CITY OF ALBUQUERQUE

October 17, 2017

Re: Cielito Lindo, 5109 Central NW
Request for Certificate of Occupancy
Transportation Development Final Inspection
Engineer's/Architect's Stamp dated 12-05-16 (K11-D085)
Certification dated 10-08-17

A1.2

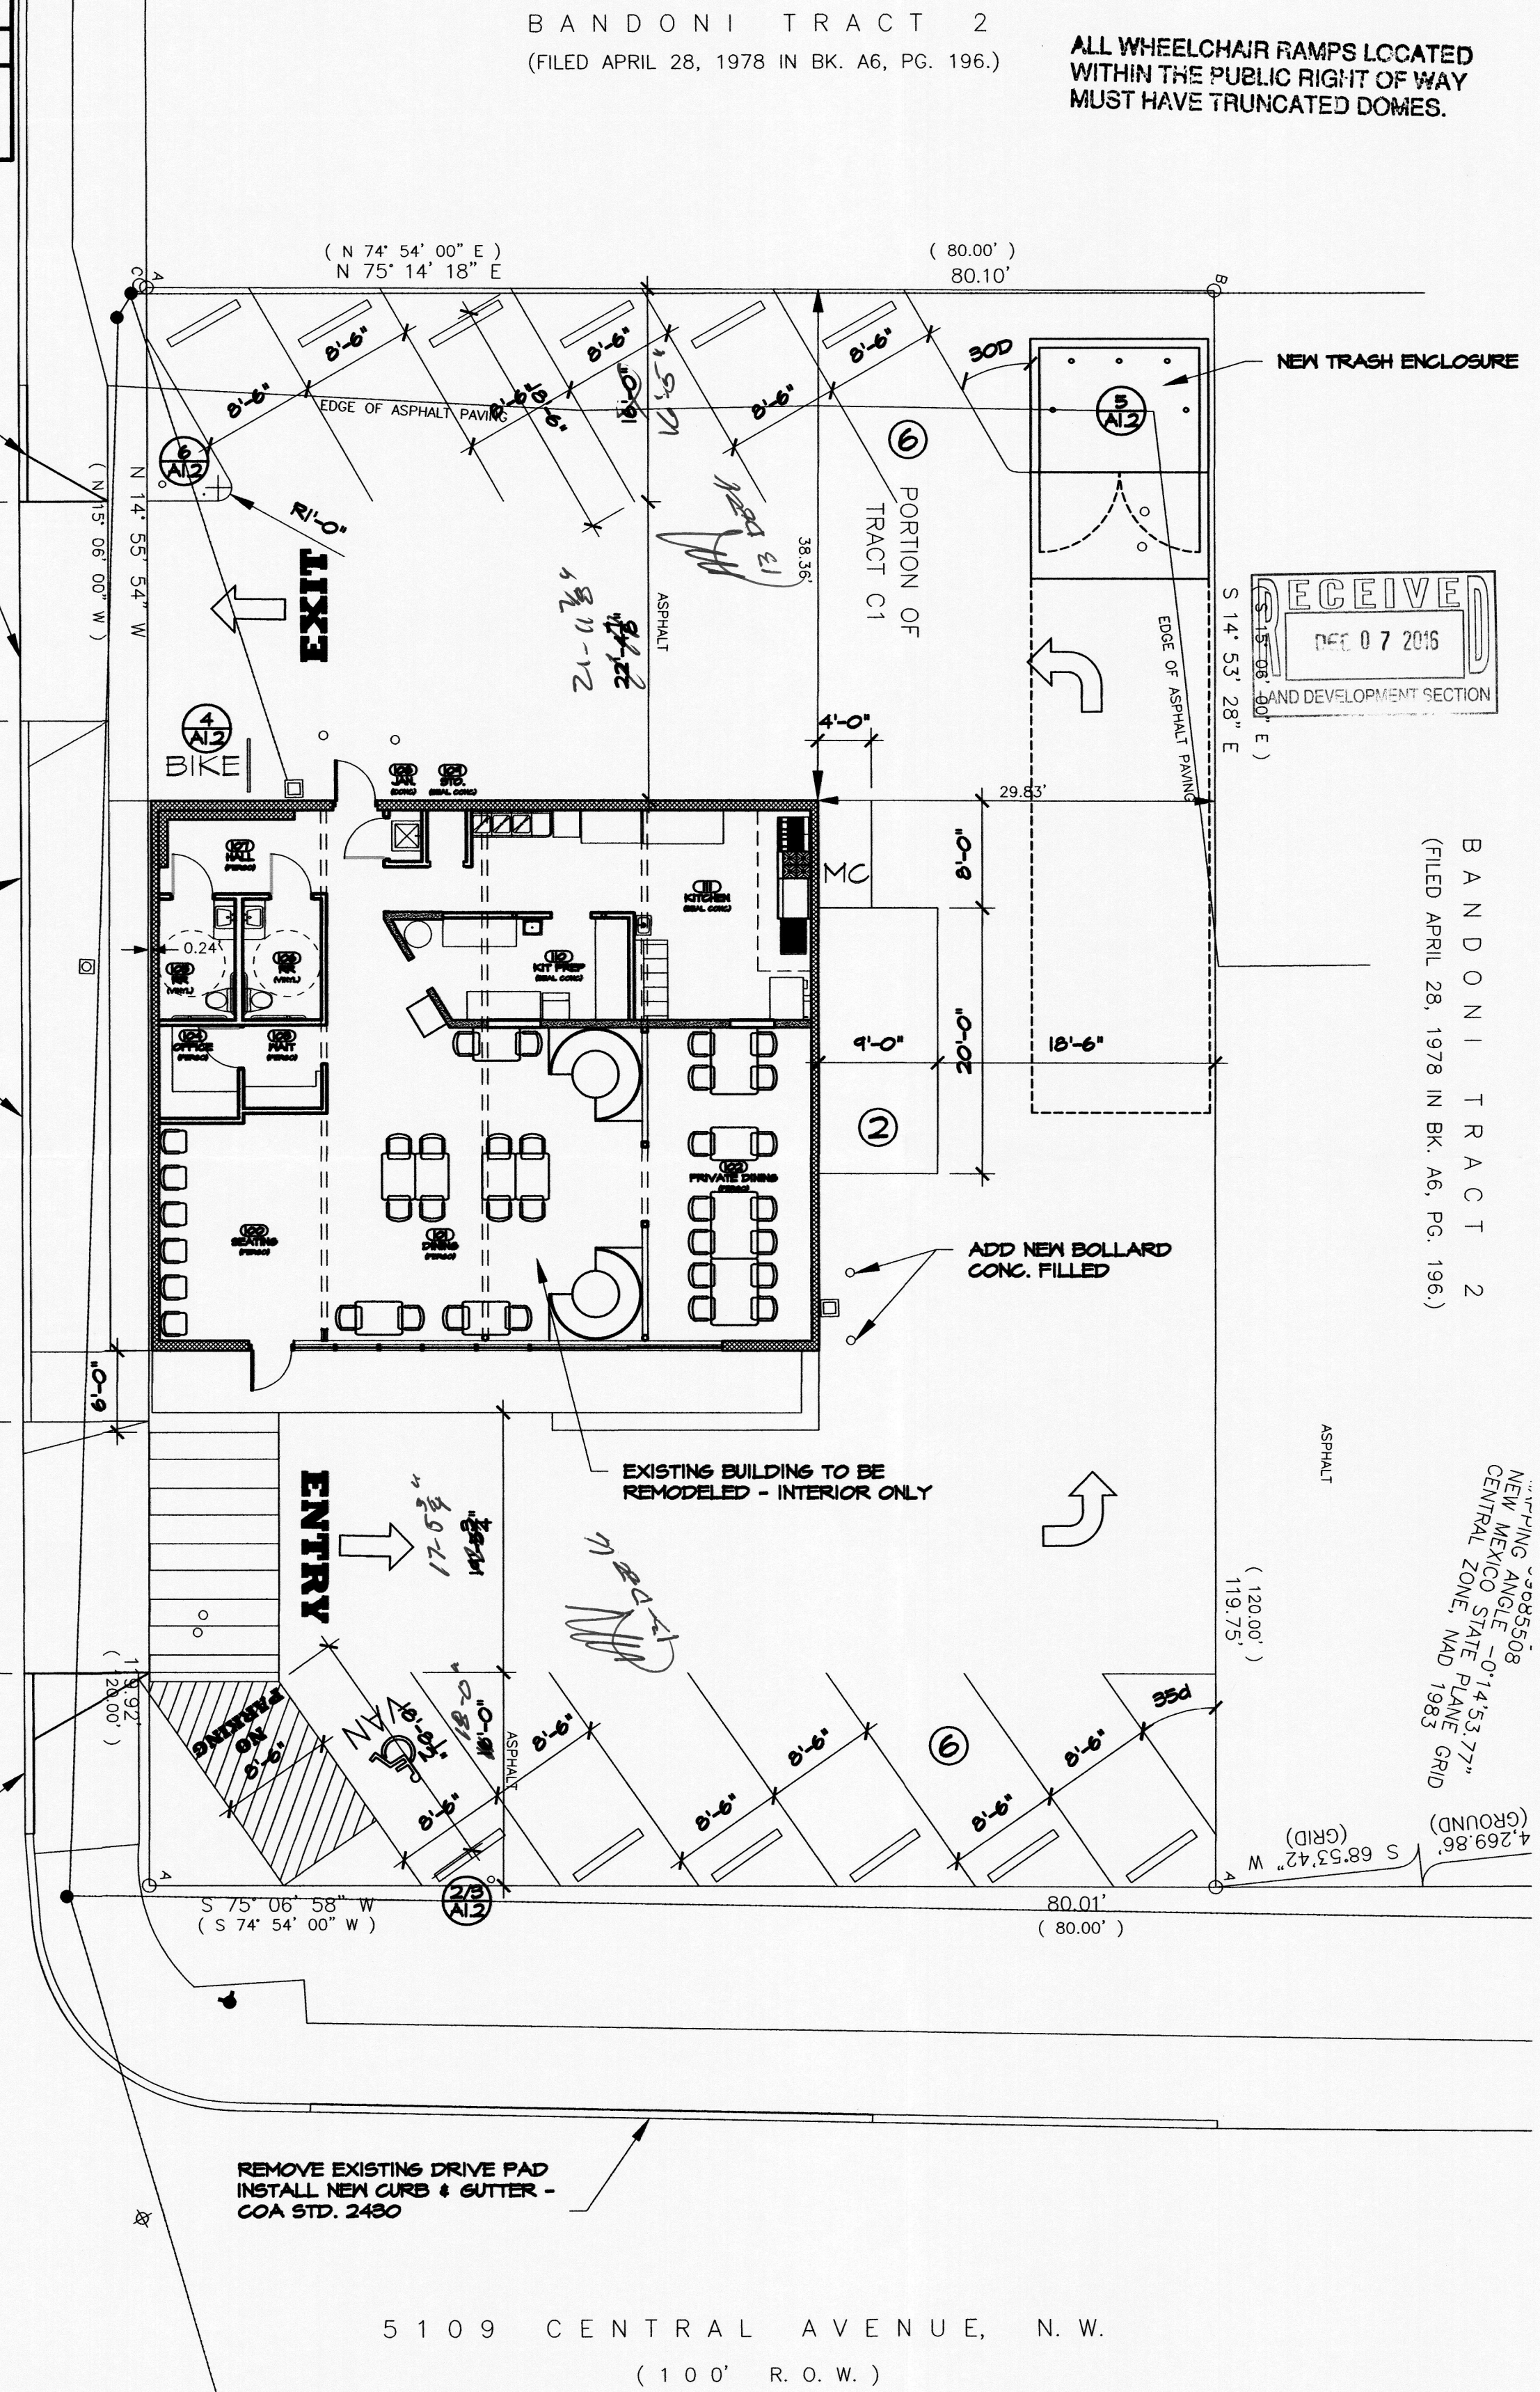
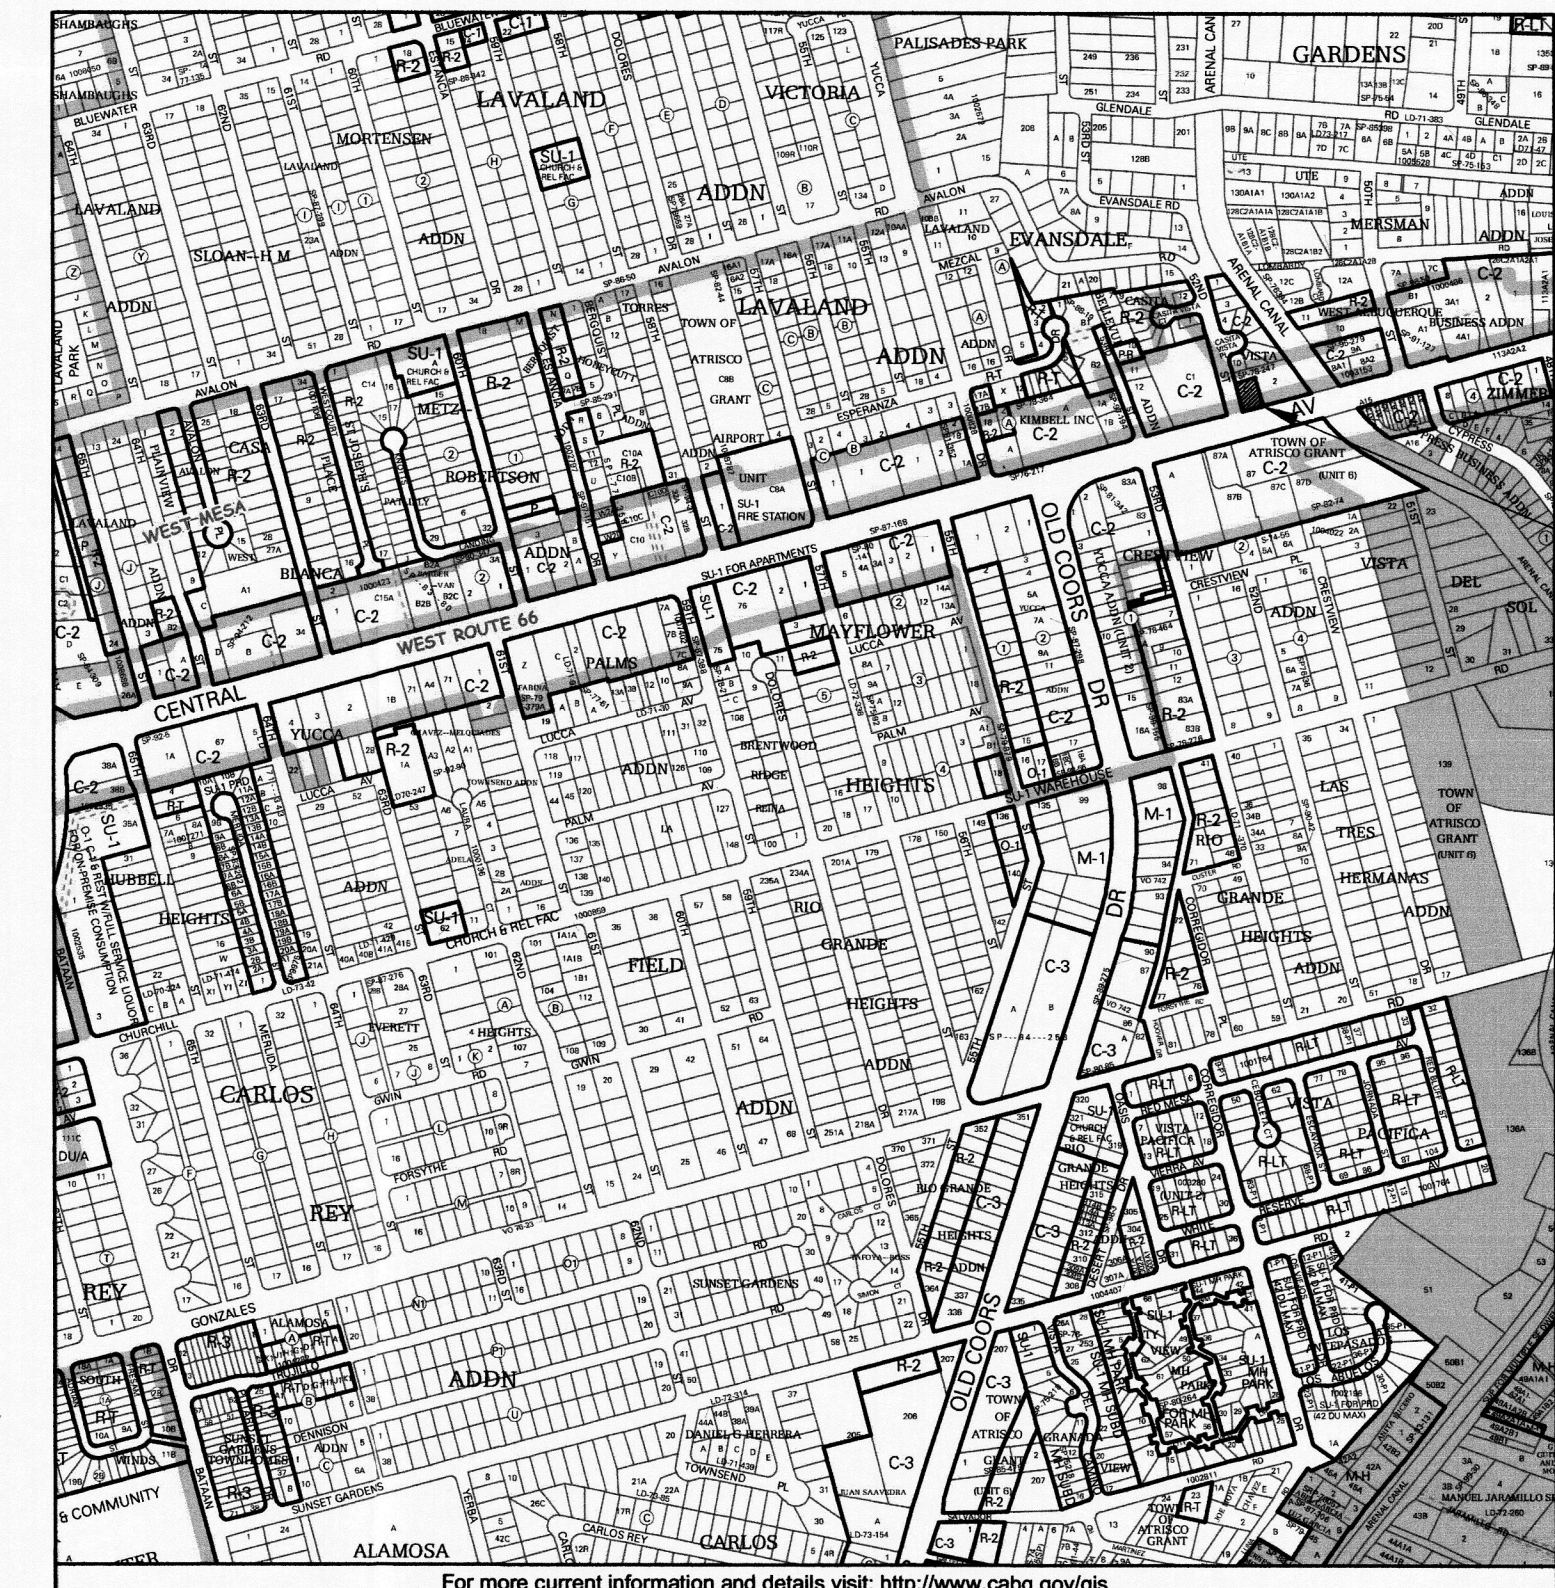
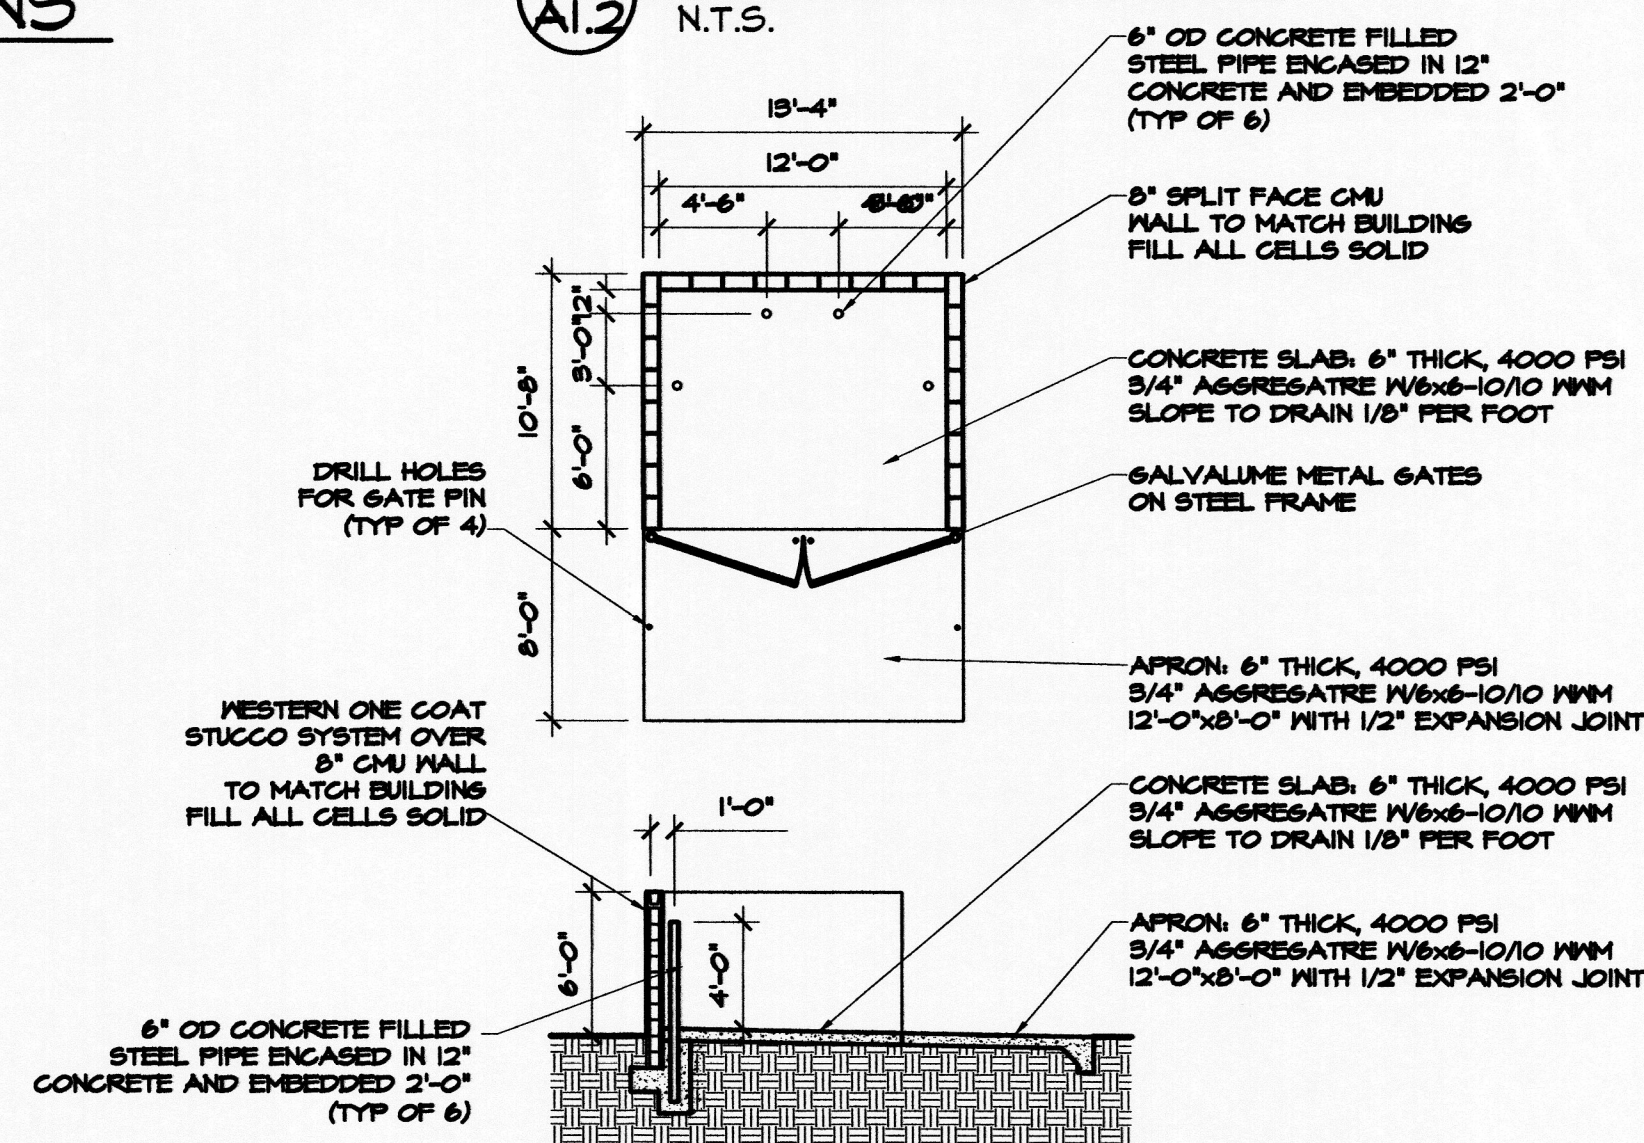
- The parking stalls located at the north of the site must be restriped to match dimensions on TCL with parking bumpers installed.
- The motorcycle parking and parallel parking space next to the building must be striped.
- Motorcycle parking space must be designated by its own posted upright sign, either free-standing or wall mounted.
- The arrows showing traffic flow and the word EXIT must be striped.
- Bicycle Rack must be installed.
- ADA parking sign must have the language as required per 66-7-352.4C NMSA 1978 **"Violators Are Subject to a Fine and/or Towing."**

- The 6 foot connection from the sidewalk to the building must be ADA accessible.
- The exit driveway on the north of the property must match the site plan and drive aisles.
